Monday 15 December 2025

Proposal: AMENDED INFORMATION: Redevelopment of the site to create the Hillingdon Watersports Facility and Activity Centre including demolition of existing Broadwater Lake Sailing Club (BSC) clubhouse at the north of the lake and erection of a building including changing facilities, meeting rooms, storage, Workshop and seasonal worker accommodation (sui generis), activity shelters; installation of pontoons and slipways; boat shed; equipment storage huts; boat parking and racking areas; camping area; outdoor activity areas; ecological enhancement throughout the site; new pedestrian routes through the peninsula; landscaping including new woodland, dense vegetation screens and boundary treatment; access road; localised dredging and land reclamation; relocation of existing sailing area and creation of floating reedbeds within the lake; coach drop off and turning area; vehicle parking; cycle parking; and associated works. (Re-consultation following submission of amended plans and documents)

Location: Broadwater Lake, Moorhall Road, Harefield

Waterway: Grand Union Canal

Dry hedge and hazel hurdle combination detail

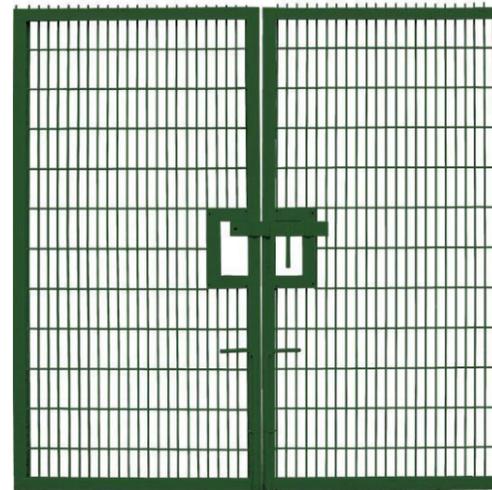
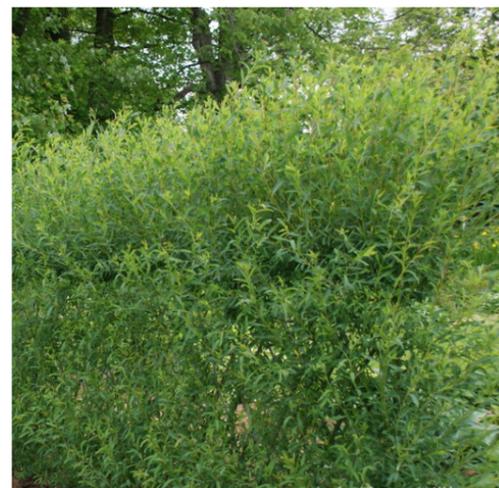
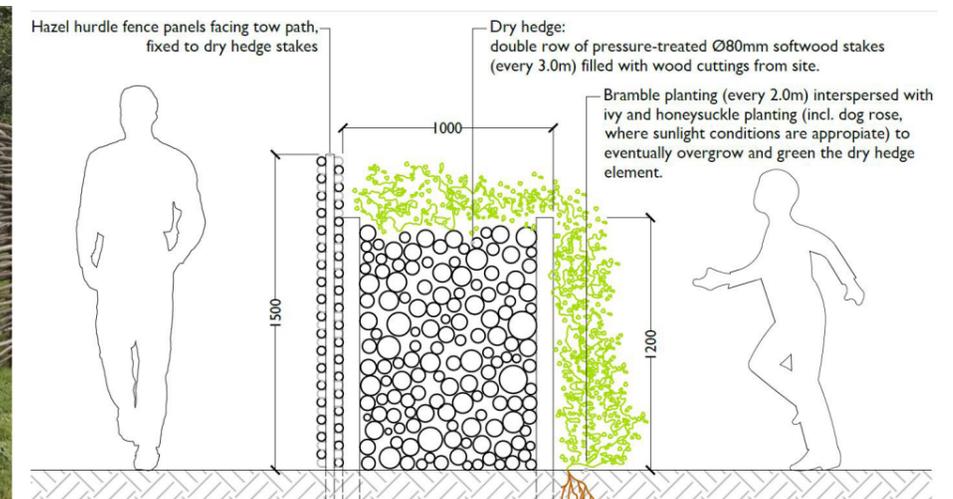
The plans have been amended in relation to the proposed boundary treatment and now show a mix of boundary treatments proposed along the canal boundary, including retention of the existing vegetation, 1.5m high hazel hurdle fence combined with dry hedging and 1.2m high dry hedging with bramble/ivy planting alongside. South of Bridge 179 the boundary treatment changes to 1.8m high V-mesh security fencing though this seems to follow the line of the existing track within the site and would therefore be set back from the canal boundary behind existing vegetation. Existing gates to the canal bridge and 3m wide access gate to the towpath are also shown to be retained which would allow new managed site access to the canal.

Any fencing should be sited to avoid tree root protection zones and existing planting to ensure the existing character and biodiversity of the waterway corridor is retained. It would be beneficial to ensure there is suitable vegetation to the outside of any fencing to screen it from the canal's outward perspective, particularly when considering its length. The final details of the proposed landscaping and boundary treatment could be addressed by condition, and the Trust wish to be consulted on this detail when available.
